CUMNOR PARISH COUNCIL

BOTLEY WEST SOLAR FARM (BWSF) REF: EN010147

In response to your 11th June 2026 invitation to respond to submissions made to your 28th April 2026 Request For Information, Cumnor Parish Council (CPC) as an Interested Party (IP) is today submitting two documents to you by email:

Illustrative Masterplan
Figure 5.5D: Cable Corridor Option D

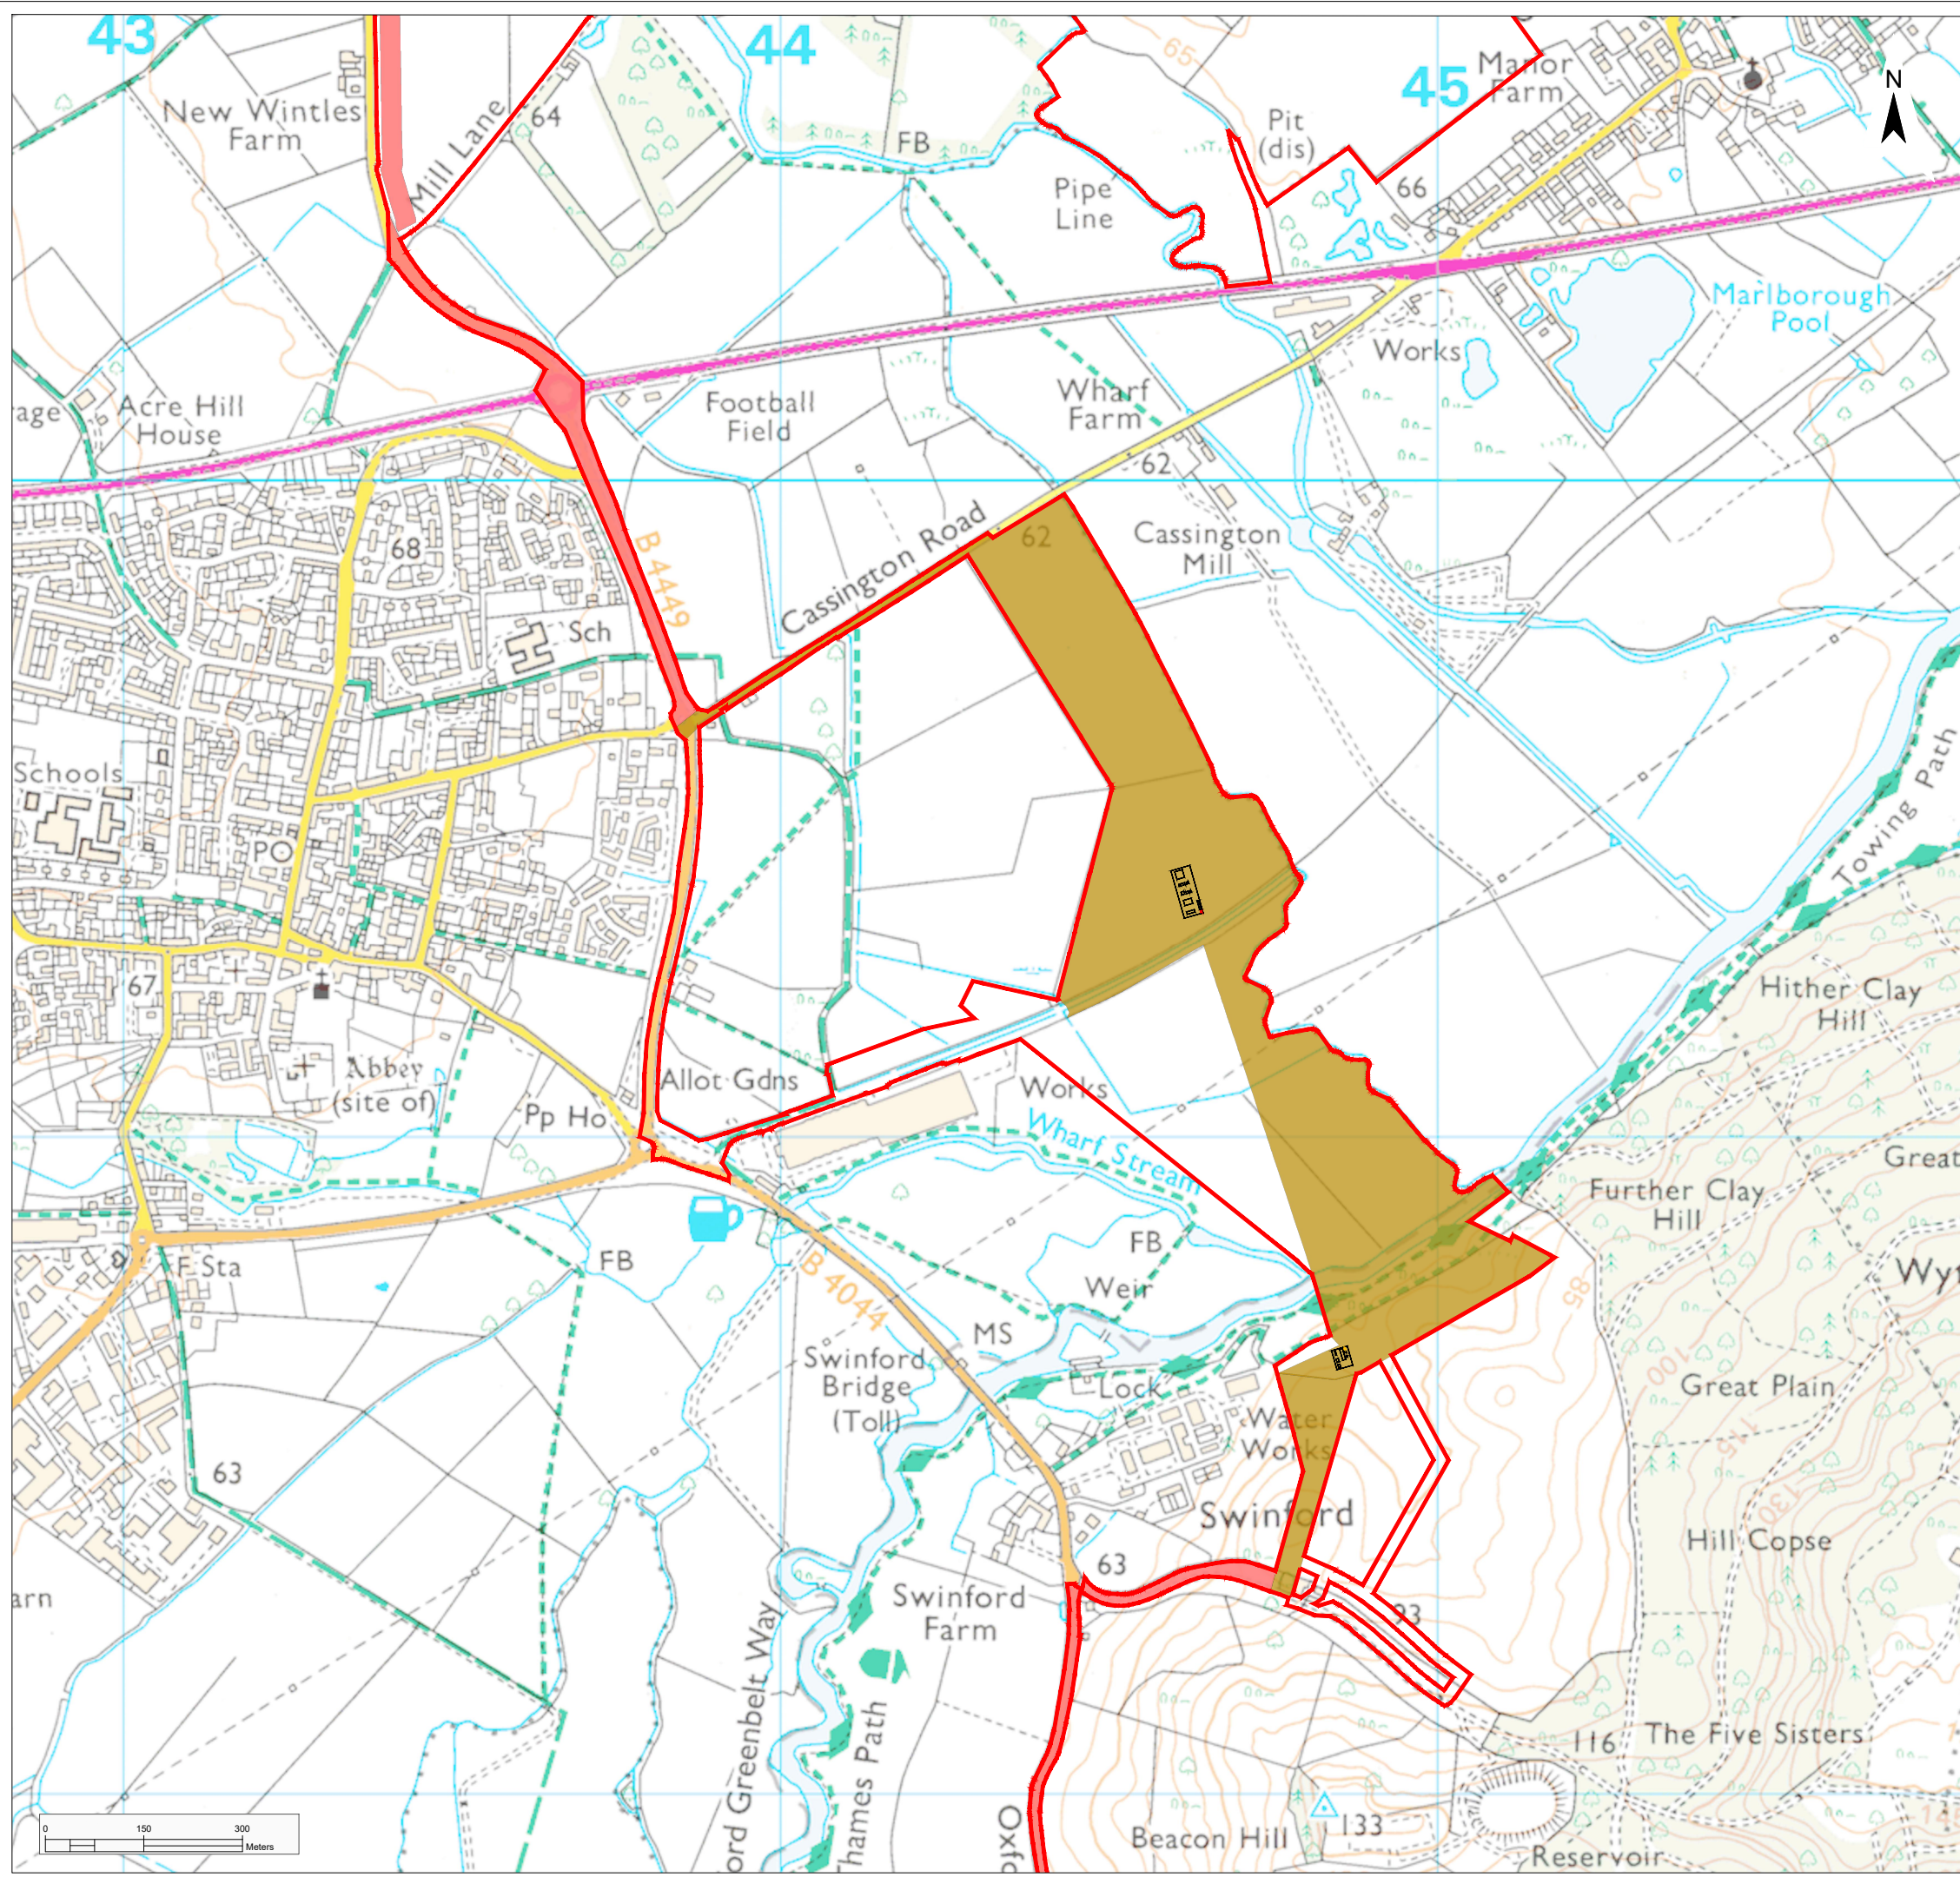
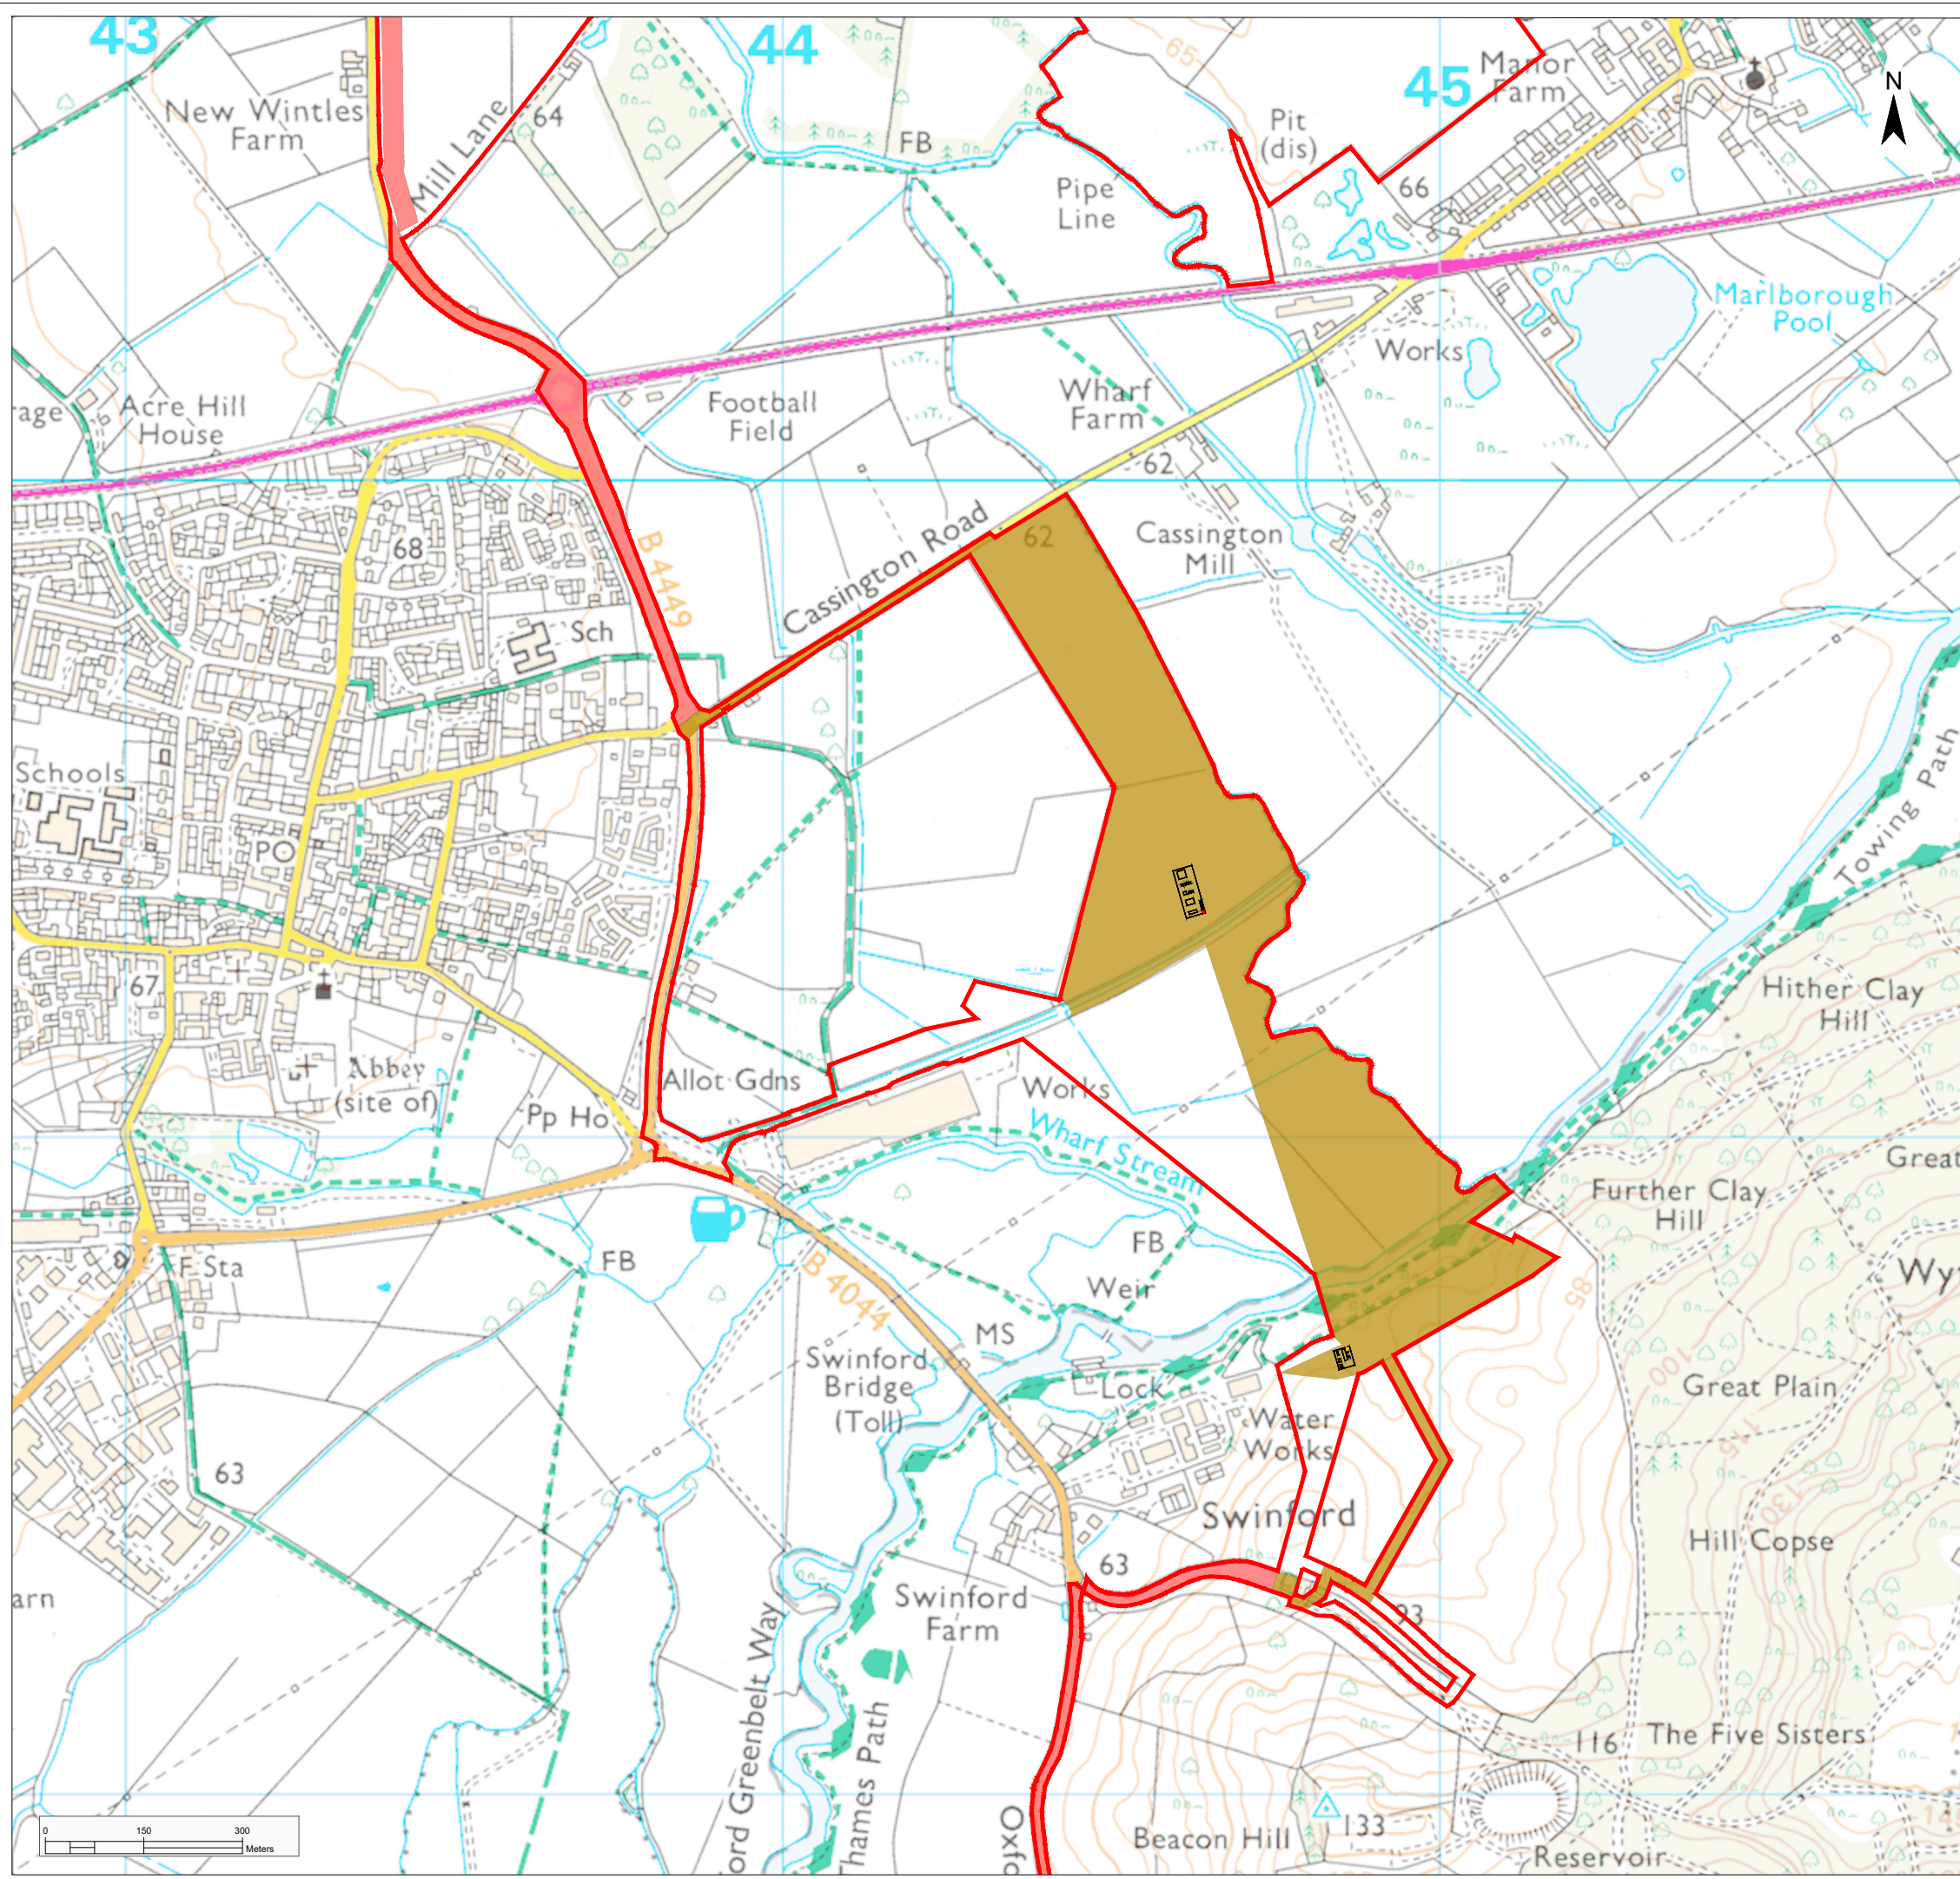
Unfortunately for the Applicant all these impediments are apparently surmountable for their proposed cable connection between the central and southern sites where there are:

- Local Nature Reserves present along the route corridor.
- Ancient woodland blocks (including Wytham woods SSSI)
- River Thames crossing at Swinford: Flood Risk Zones 2 and 3 are present at this crossing - Environment Agency consent required.
- Additional Flood Zone 2 / 3 sections present including the B4044 SW of Swinford (see Map 2 - EA flood risk map - below)

Surprisingly given the Applicant's stated unwillingness to address these impediments for a contrived cable route to Cowley, it is apparently content to cope with them for its central site to southern site cable route.

Except of course it hasn't addressed them in this case either, the prime example being the absence of a '*detailed flood risk assessment*' that satisfies this Interested Party or the OHA for the southern site and the central to southern site cable routing.

Also unexplained is why, if the Applicant is unwilling to bear a cost of c. £10m/km for cabling to Cowley (the Applicant quotes a cost of £150m for 15km to Cowley from the southern site **C1-087 pages 9 and 10**), it is willing to bear that same £10m/km cost, with a total of at least £70m for the c. 7km cable route between the central and southern sites traversing the River Thames near to Swinford Toll bridge in a EA Flood Zone 3 area?
